Recommendation Report for Planning Permission for Works or Extension to a Dwelling

REF NO: BE/83/19/HH

LOCATION: 13 Central Avenue
Bersted
PO21 5HT

PROPOSAL: Single storey rear extension

PROPOSED GROUND FLOOR LAYOUT
SCALE 1:50

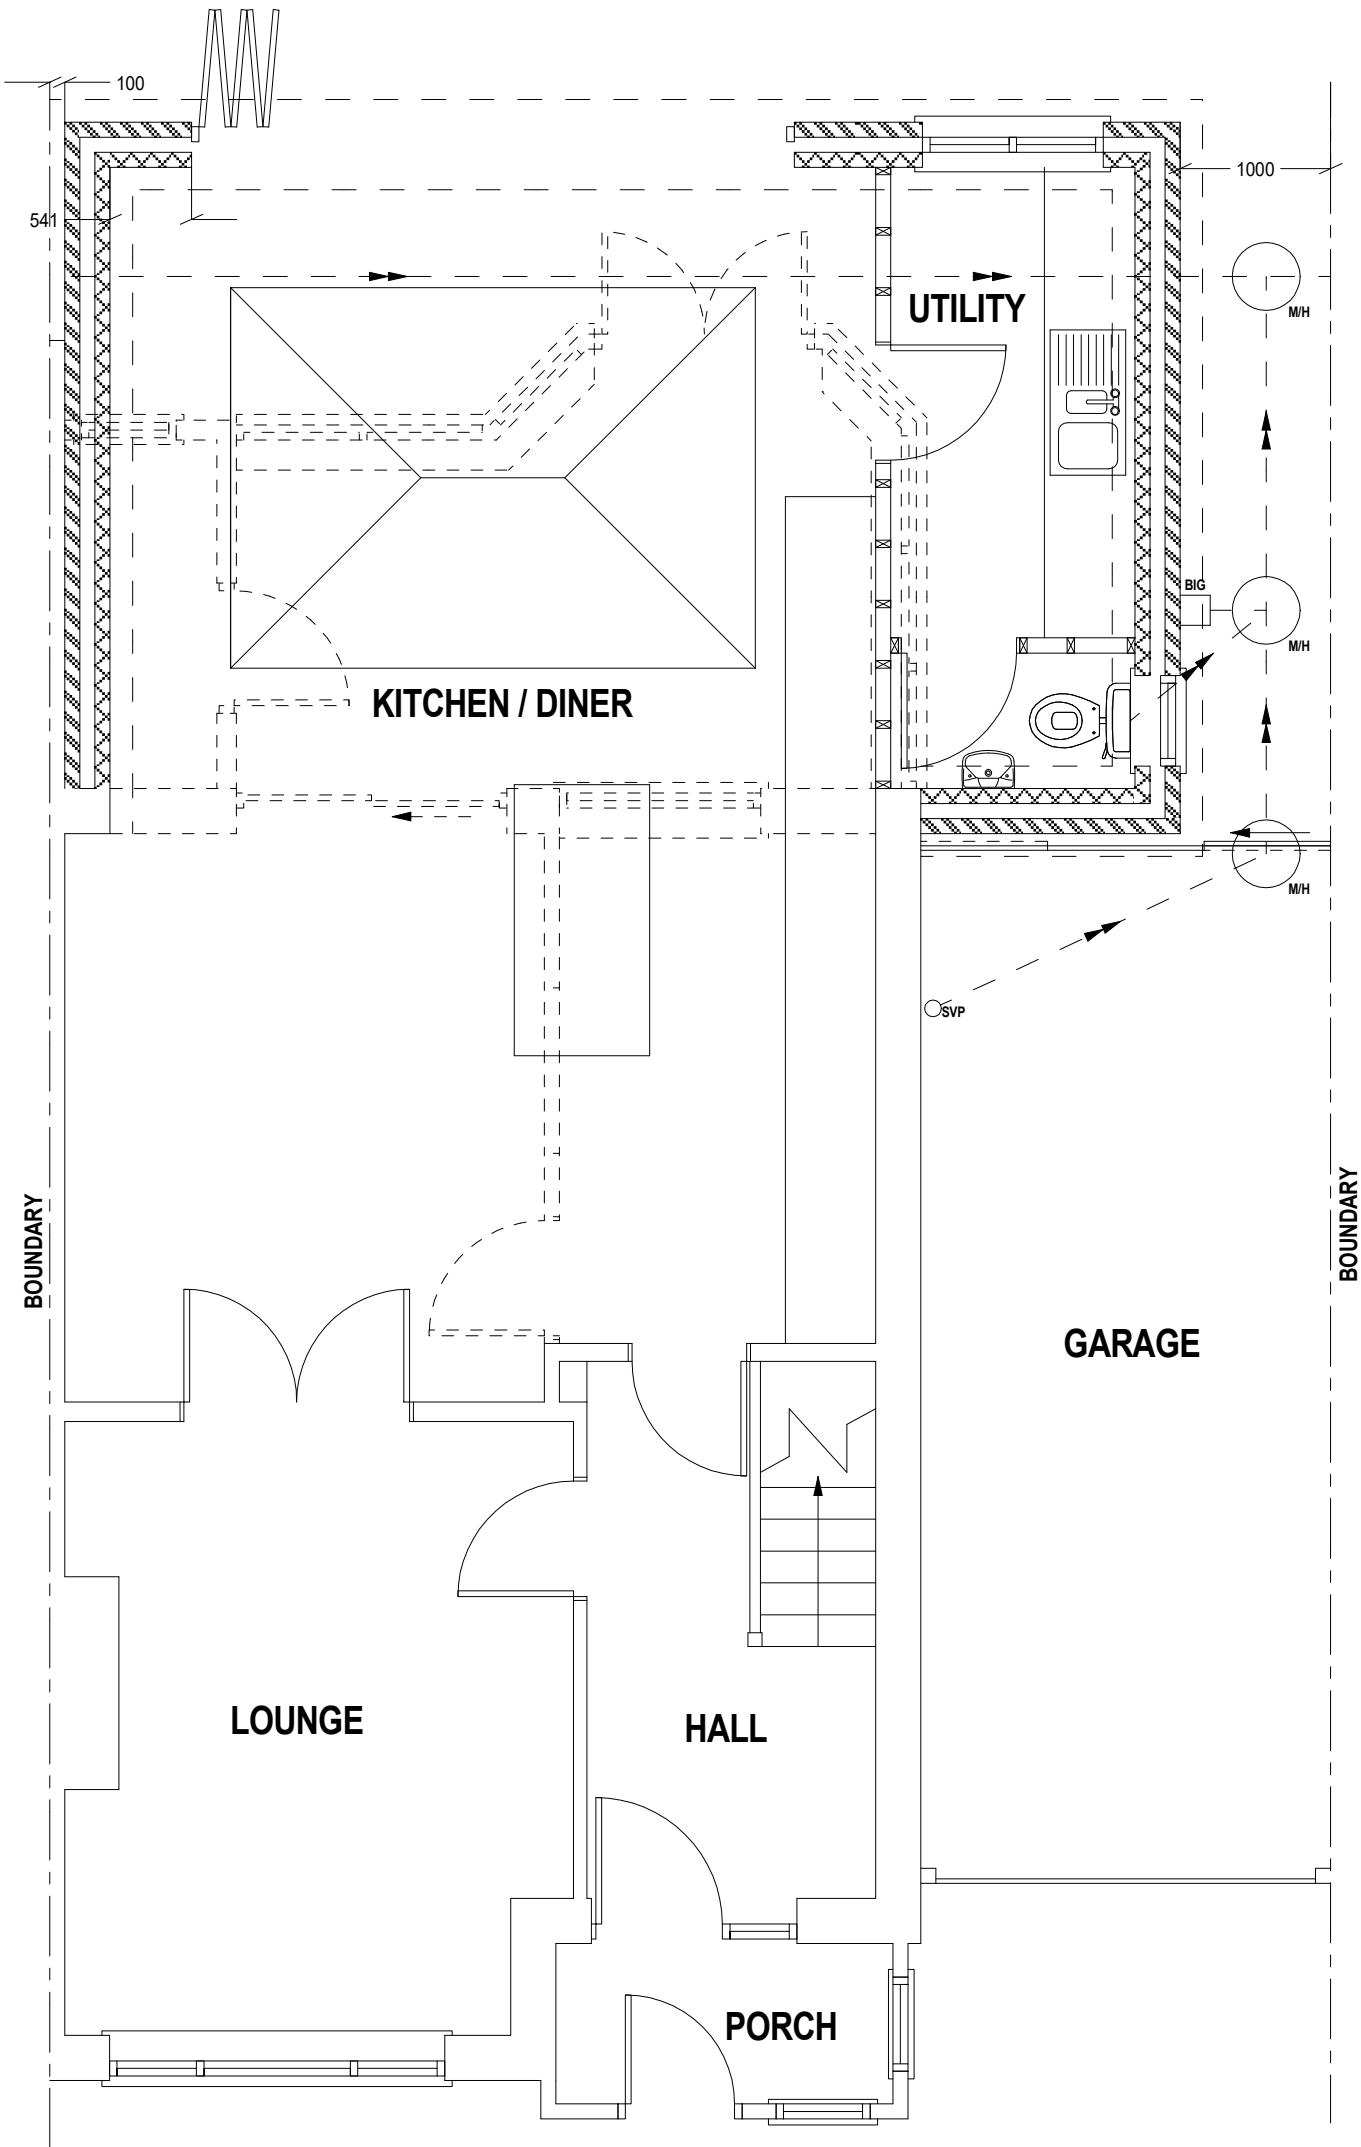
The extension will replace an existing conservatory however will increase in depth by 1.5m with a total depth of 4.5m. It will have a flat roof with a height of 3.15m and 3.75m with roof lantern.

To the neighbouring property at No.11 a garage is located at the boundary. There is however a window to the rear of this and due to its siting the extension will intersect a 45 degree line drawn from the centre of the window. Whilst it does intersect, there is 1m retained to the boundary and with boundary treatment in place also, it is not considered to give rise to significant overbearing or overshadowing in which a refusal is justified.

The extension will have doors to the rear and resultant views will be of the rear garden. There will also be an additional window serving a bathroom to the eastern elevation however at ground floor level with fencing in place, views again are not considered significant.

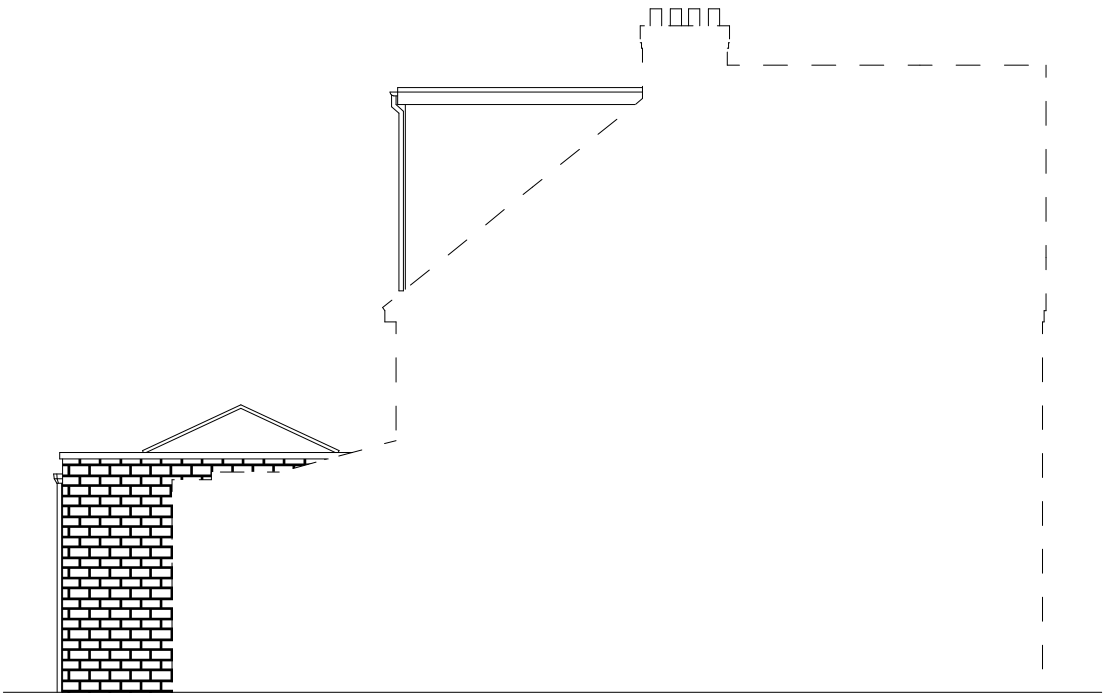
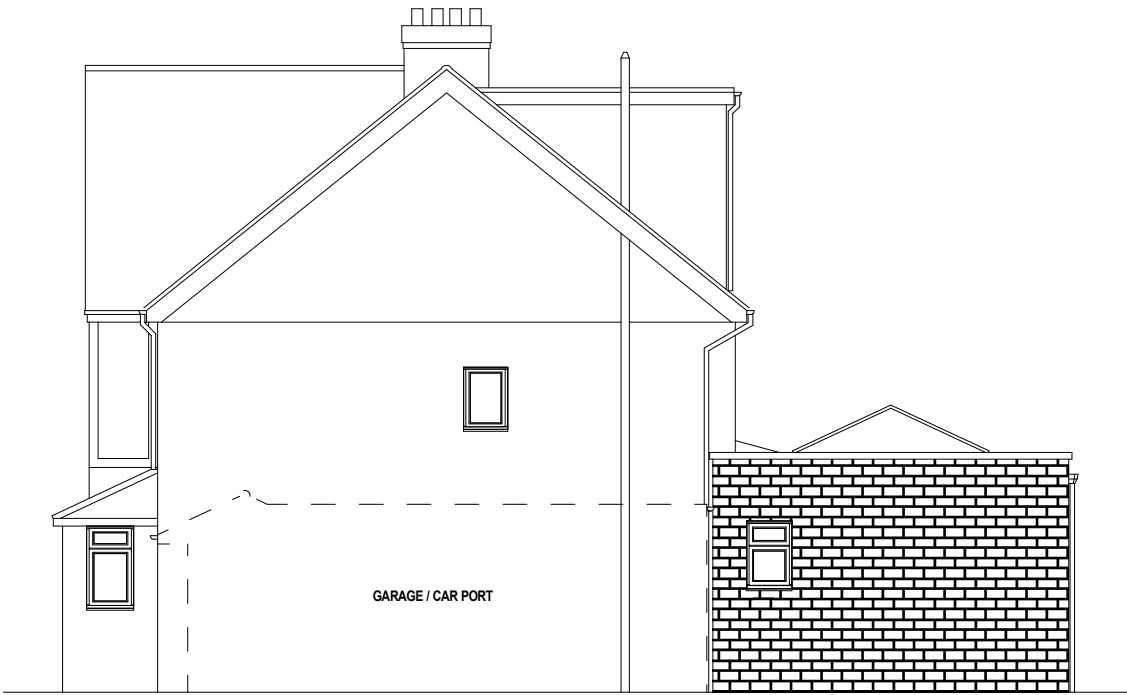
The proposal will be situated to the rear of the dwelling. As it extends along the rear the roof will be partially visible from the front due to its siting, however views will be minimal.

The extension is quite large, however at single storey it appears subservient to the host dwelling. Materials will also match that of the host dwelling which helps the development appear sympathetic in appearance.
